Your reference: MP06_0273 MOD 3

Modification to Site 4B Commercial Development (MP06_0273 MOD 3)

Andrew Brown
Executive Manager
Urban Planning and Design

Figure 6: Additional tree proposed for removal (dotted blue)

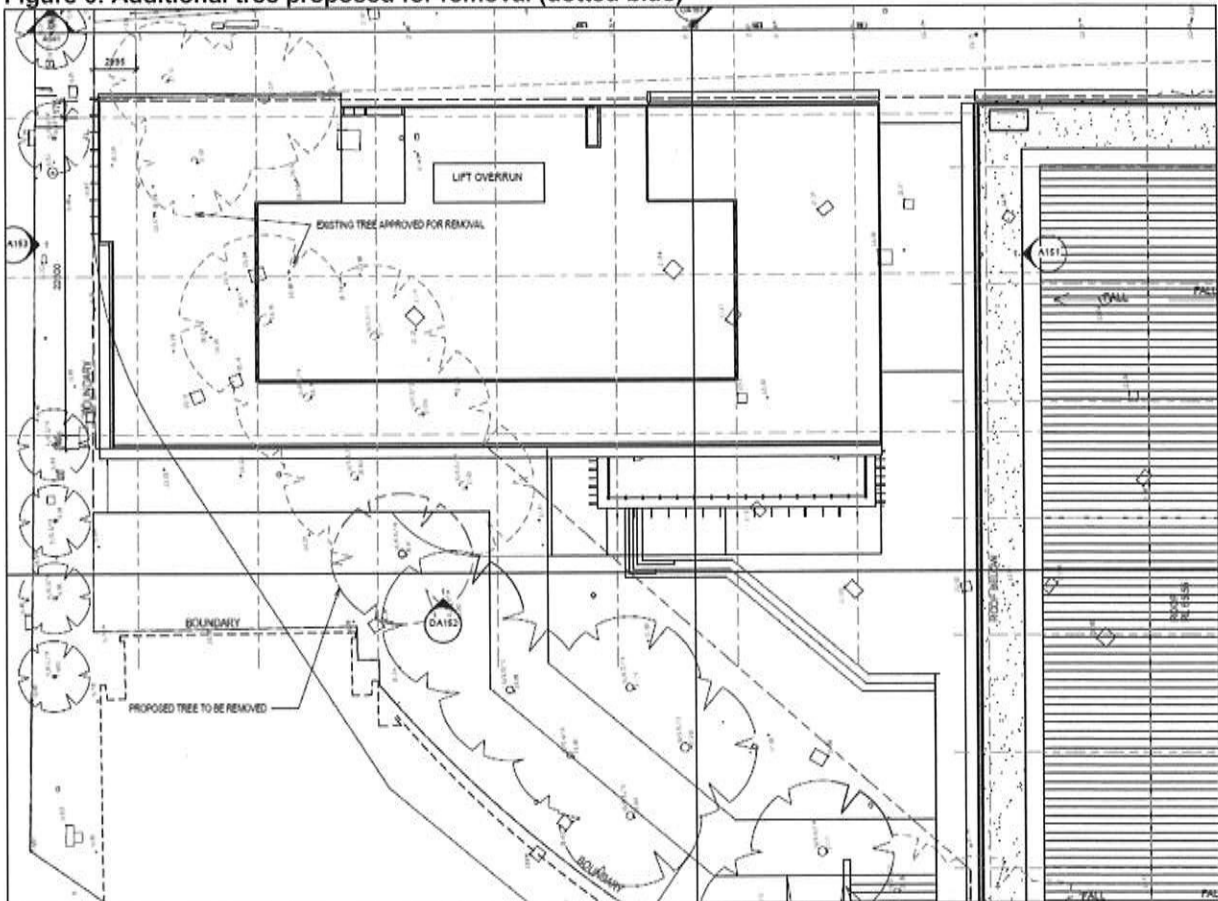
- The proposed modification to the basement levels of Stage 1 and Stage 2 will potentially endanger 4 to 5 brush box trees previously identified as being retained. This should be clearly identified as part of the revised development.
